Re: Pedestrian Level Wind Study Addendum
265 Centrum Boulevard, Ottawa
Gradient Wind File 23-023 June 2024

The City of Ottawa provided the applicant, Demarco Construction and Bayview Orleans Inc., with the following comments:

**FIGURE 6A: WINTER – WIND COMFORT, GRADE LEVEL – PROPOSED MASSING**

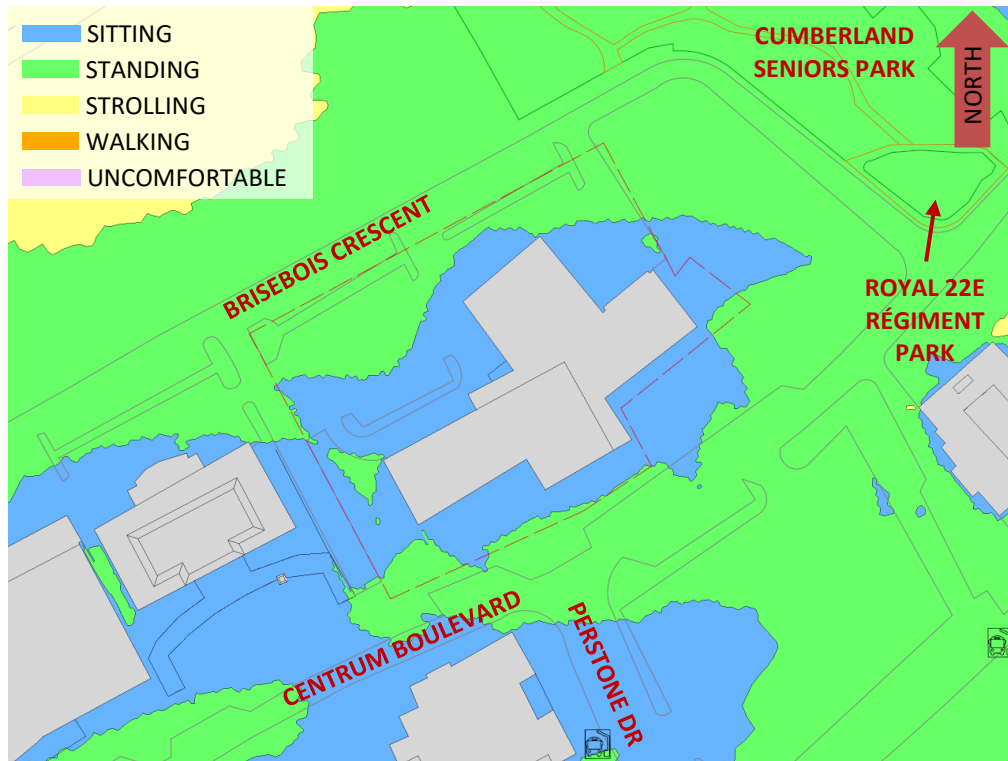
“Wind conditions over the stair feature linking the lower and upper grade levels are predicted to be uncomfortable for 30% of the time during the winter season. While a freestanding canopy is proposed, the architects and wind consultant are asked to work together to show and explain what massing changes would alleviate this condition and remove the need for a canopy, and to show this with a new wind study.”

The central stair feature is an urban design element that links and connects Brisebois Crescent to Centrum Boulevard. The stair feature is a transitional area that links the two grade levels and pedestrian usage is expected to be short without pedestrians lingering in the area. The proposed freestanding canopy would provide pedestrians with shelter from the elements, including during periods of strong winds, and is expected to improve pedestrian comfort over the stair feature.

**FIGURE 7A: TYPICAL USE PERIOD – WIND COMFORT, GRADE LEVEL – PROPOSED MASSING**

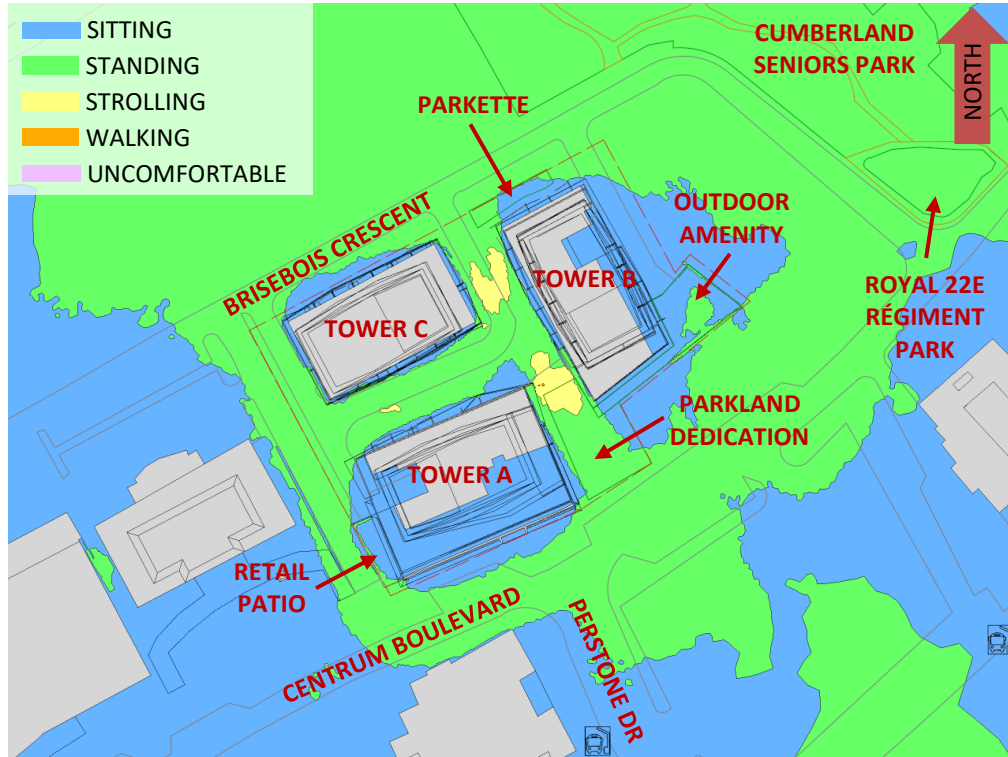
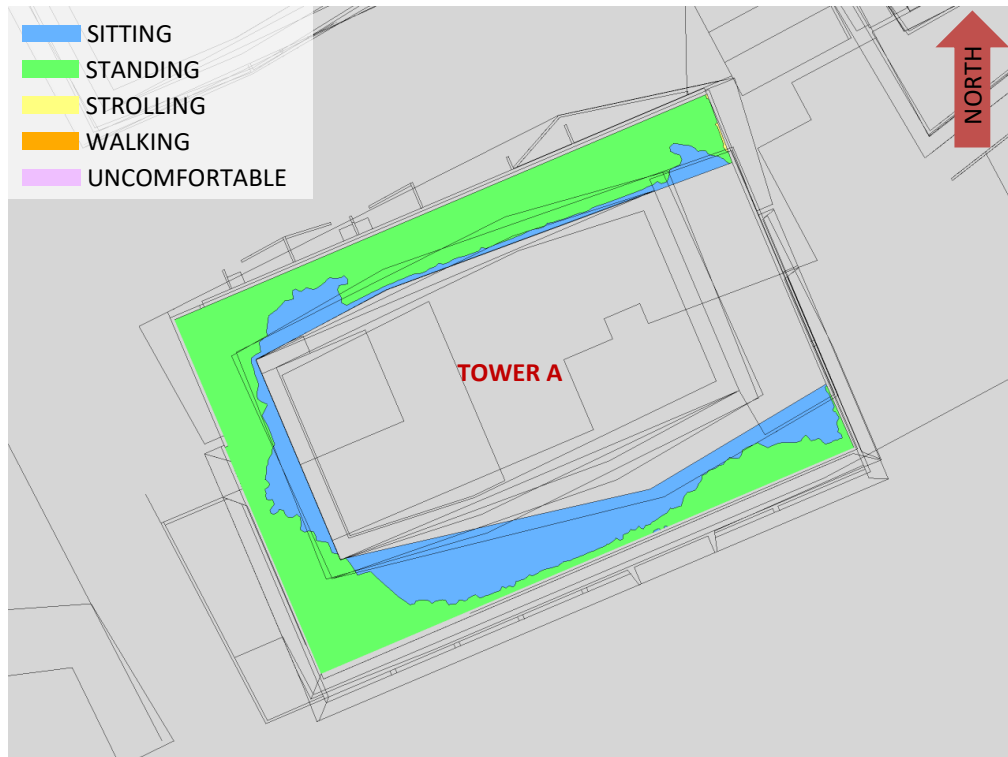
“Post development wind conditions in the existing Cumberland Seniors Park and 22e Régiment Park will only be suitable for standing during the typical use period. It is not acceptable to create a new condition where wind conditions make it uncomfortable to sit in a public park. The architects and wind consultant are asked to work together to show and explain what massing changes, including reductions in height, would be necessary to maintain the existing range of use of the parks and show this with a new wind study.”

While windier conditions within the existing Cumberland Seniors Park and the 22e Régiment Park are predicted following the introduction of the proposed development, conditions within the two parks are also predicted to be suitable for sitting for at least 70% of the time during the typical use period, where the target is 80% of the time to achieve the sitting comfort class. Notably, the two parks have limited seating areas and benches, and are mostly comprised of walking pathways. As noted in the Ottawa Terms of Reference (Wind), conditions suitable for strolling may be considered acceptable for sidewalks associated with mainstreets, plazas, and parks.

Furthermore, trees, vegetation, and other existing and planned landscaping elements were omitted from the simulation model, as is industry standard practice, due to the difficulty of providing an accurate seasonal representation of vegetation. The landscaping elements that could not be included in the simulation model, notably the existing trees and vegetation within the two parks, are expected to somewhat improve pedestrian wind comfort within the parks. In addition, the covered gazebo at the centre of the 22e Régiment Park is expected to provide conditions that are comfortable for sitting beneath the gazebo.
